Development Demolition of existing dwelling (No. 32) & erection of 4 No. 4 bed dwellings, alterations to existing dwelling (No. 34A) with alterations to two existing accesses to form a single point of access. This application may affect the Ferring Conservation Area.

Location 32 & 34A Sea Lane Ferring

I regret that I am unable to accept your documents as a formal application until the following item(s) have been received or resolved :-

Plot 1
Proposed Plans and Elevations

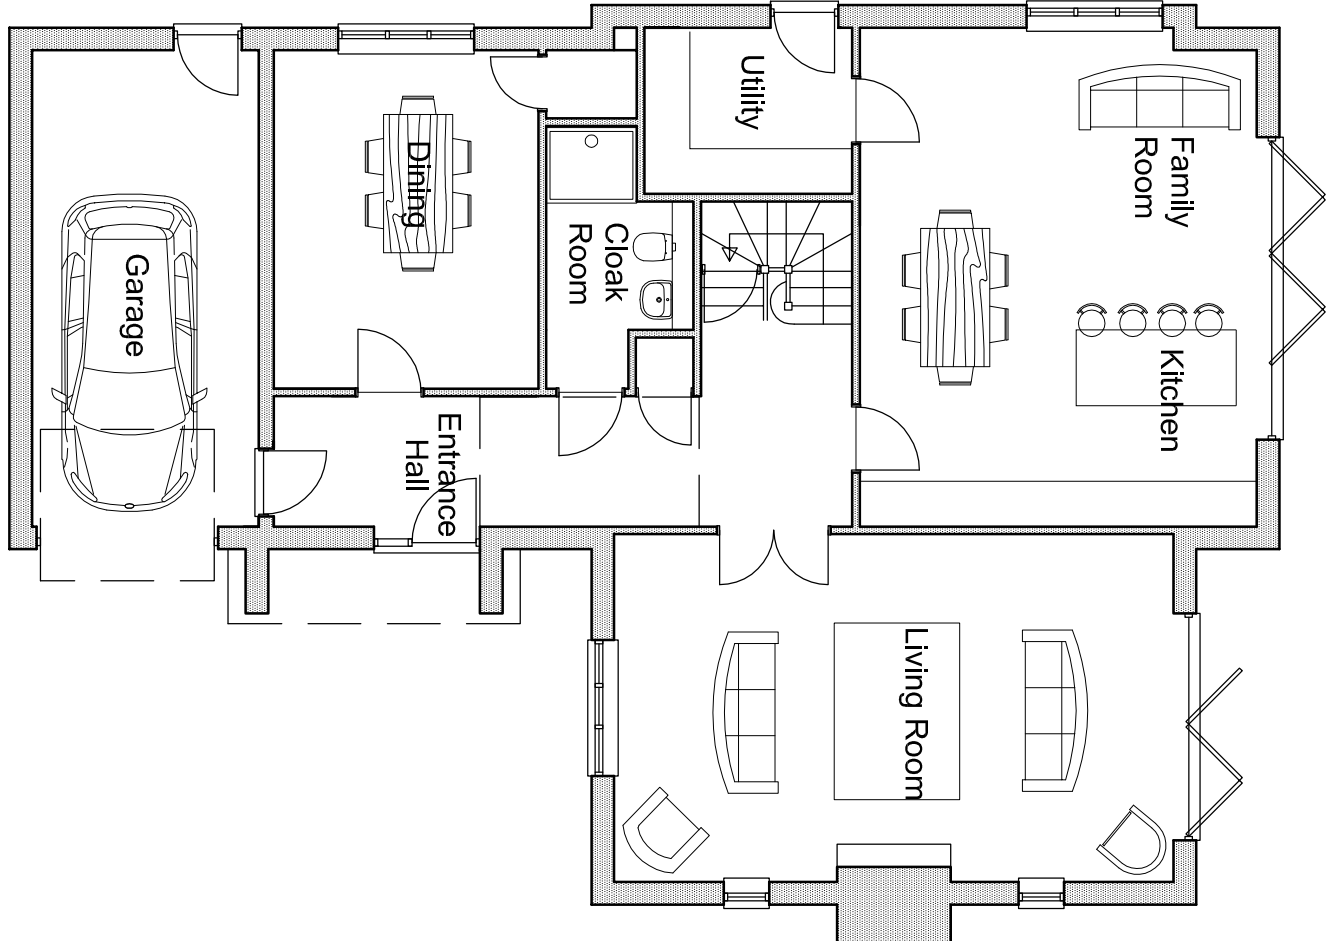
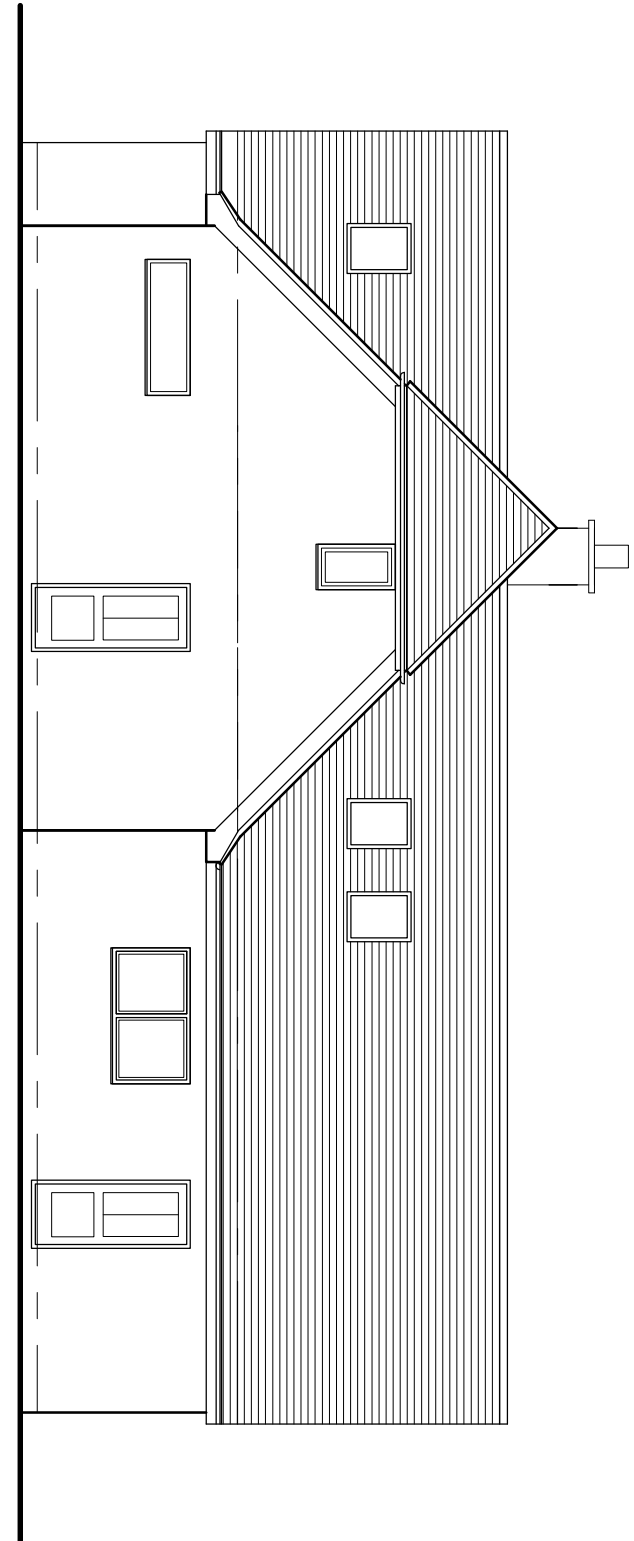
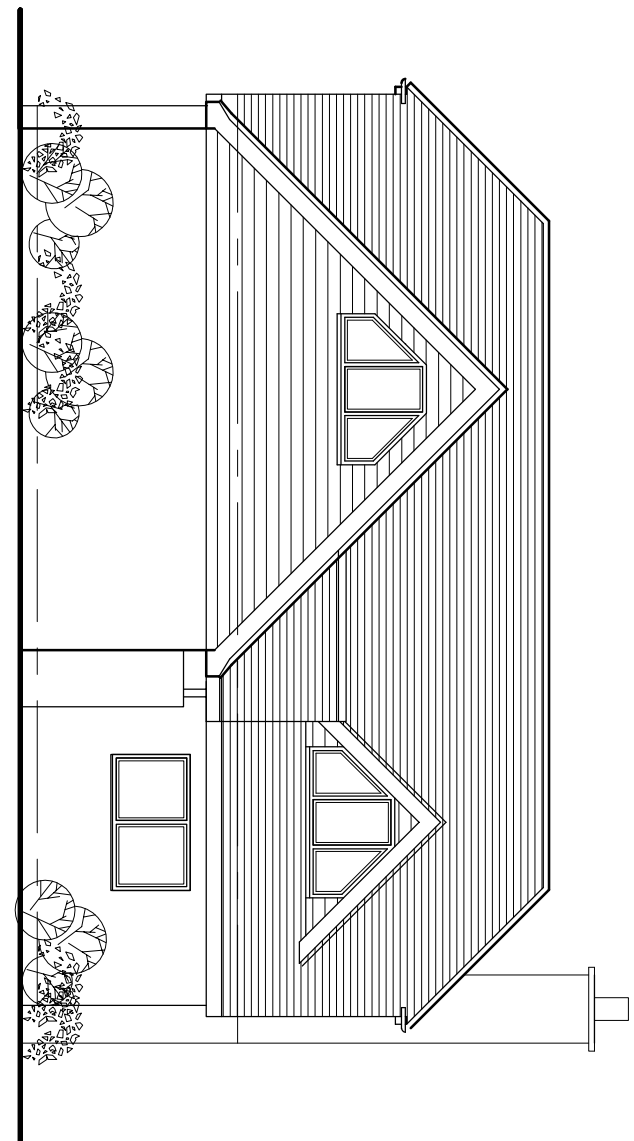
The proposed north ground floor plan and elevation do not accord on Plot 1. Please amend accordingly.

DRAWING TITLE		
Plot 5 Proposed Plans and Elevations		
DATE	SCALE	DRAWN BY
Mar 2017		GM
CHECKED BY		
JOB NO.	DRAWING NO.	REVISION
1687	2.05	B

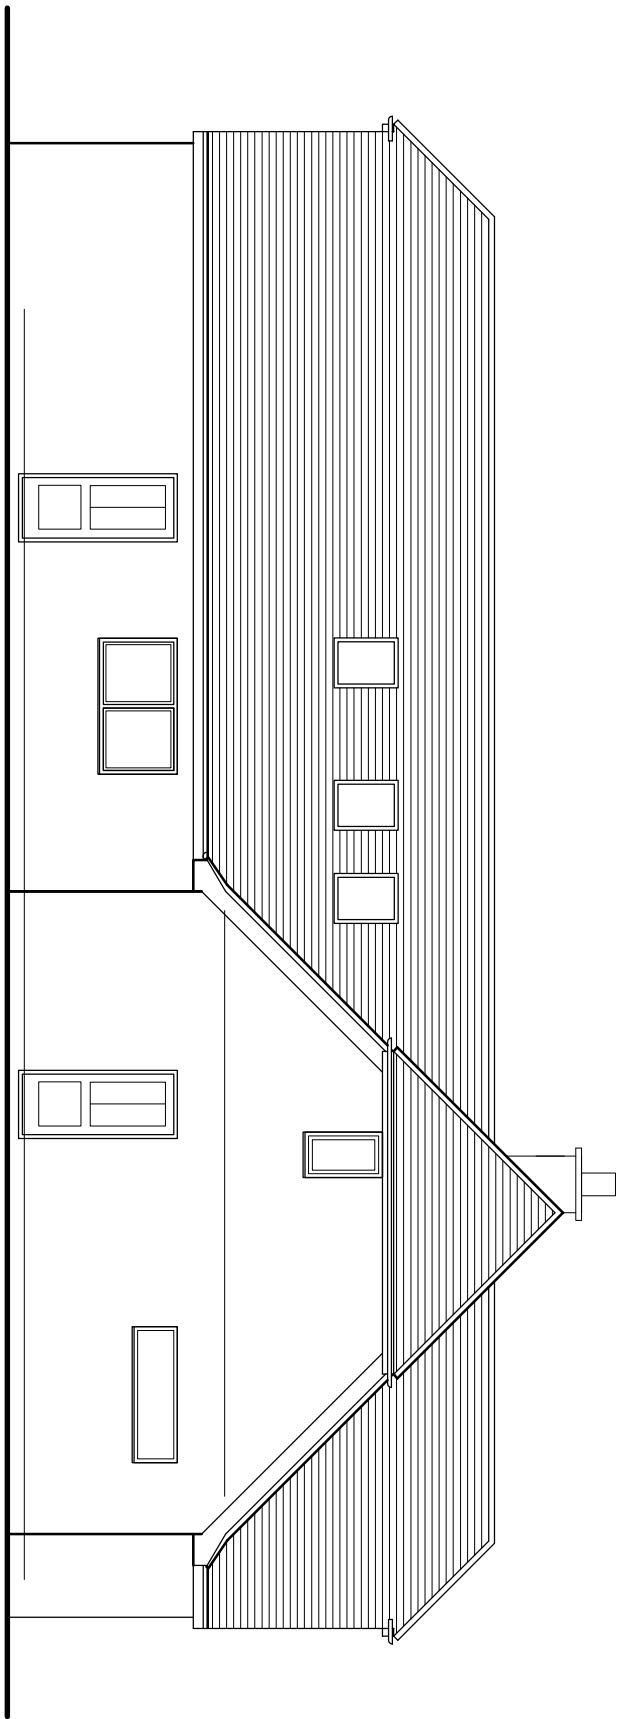
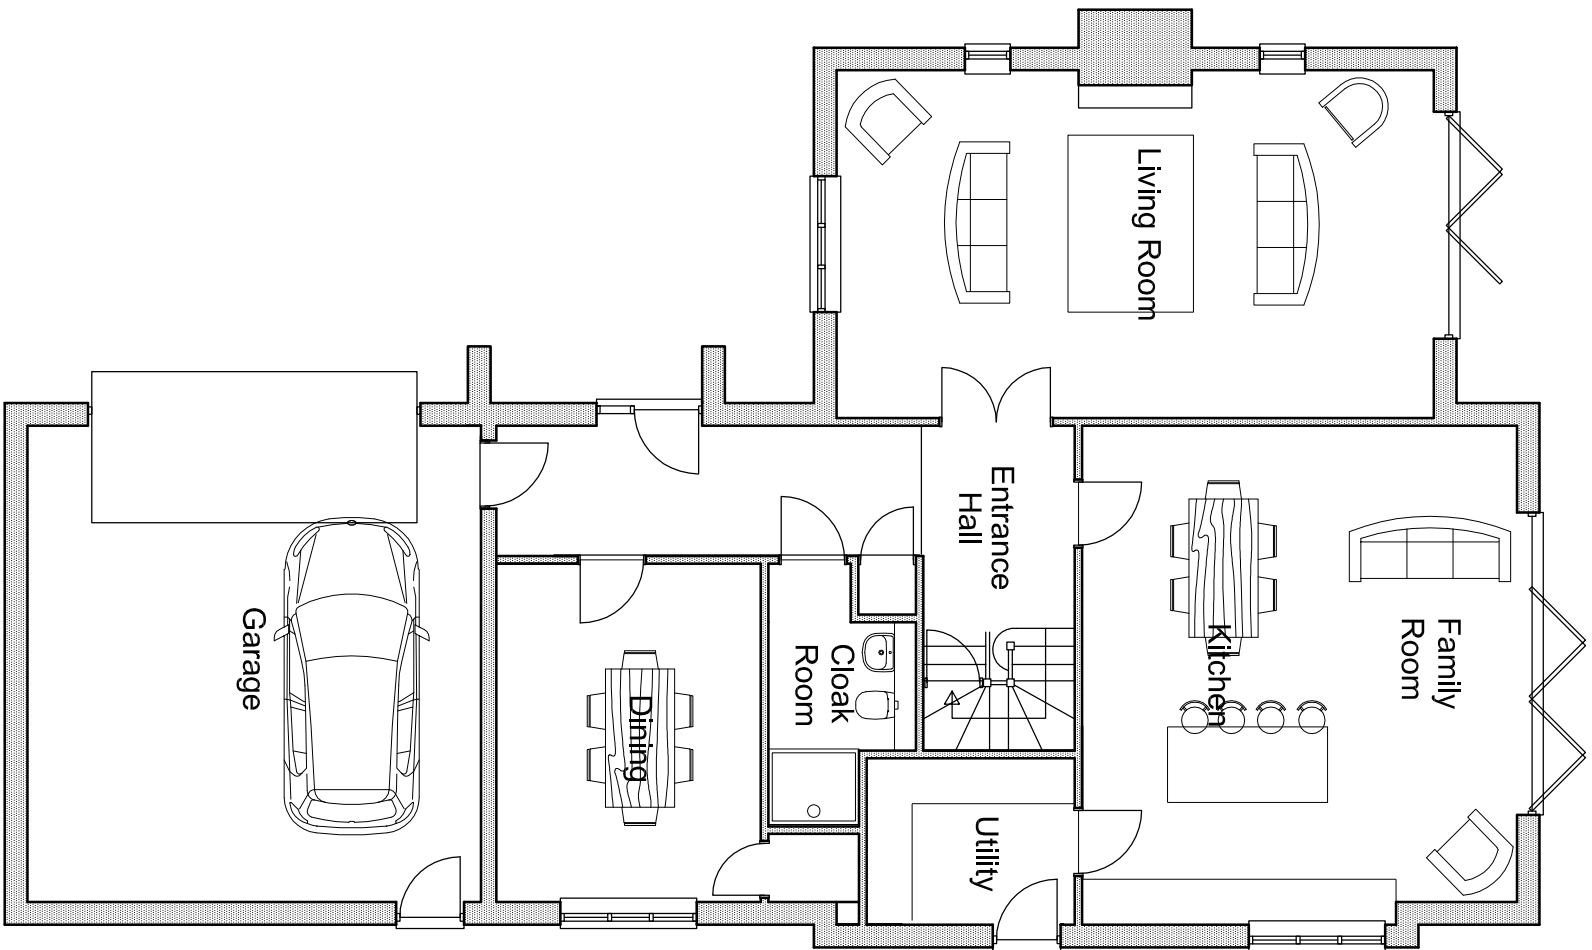
The proposed north ground floor plan and elevation do not accord on Plot 5. Please amend accordingly.

Plot 2 - Existing dwelling
Proposed Plans and Elevations

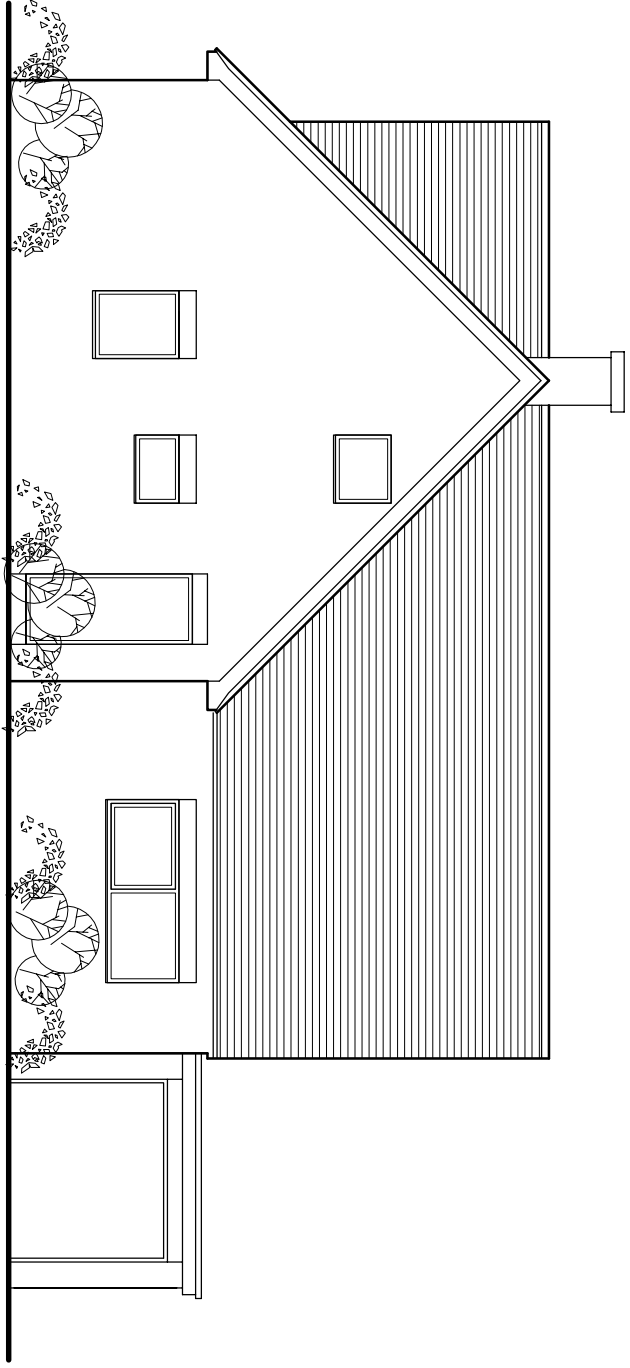
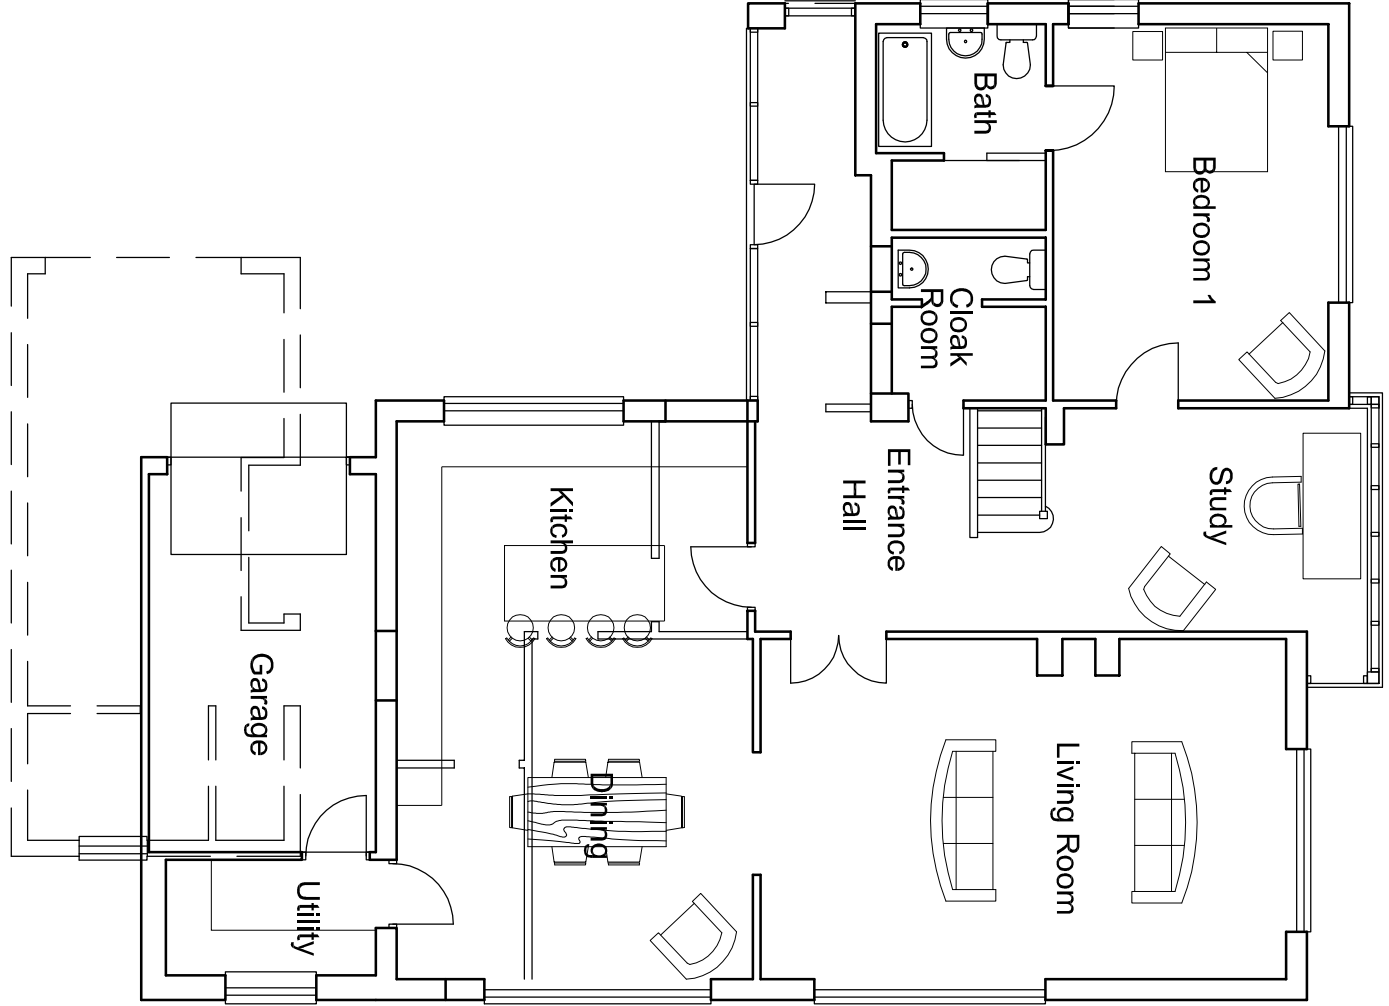
The proposed east ground floor plan and elevation do not accord on Plot 2. Please amend accordingly.
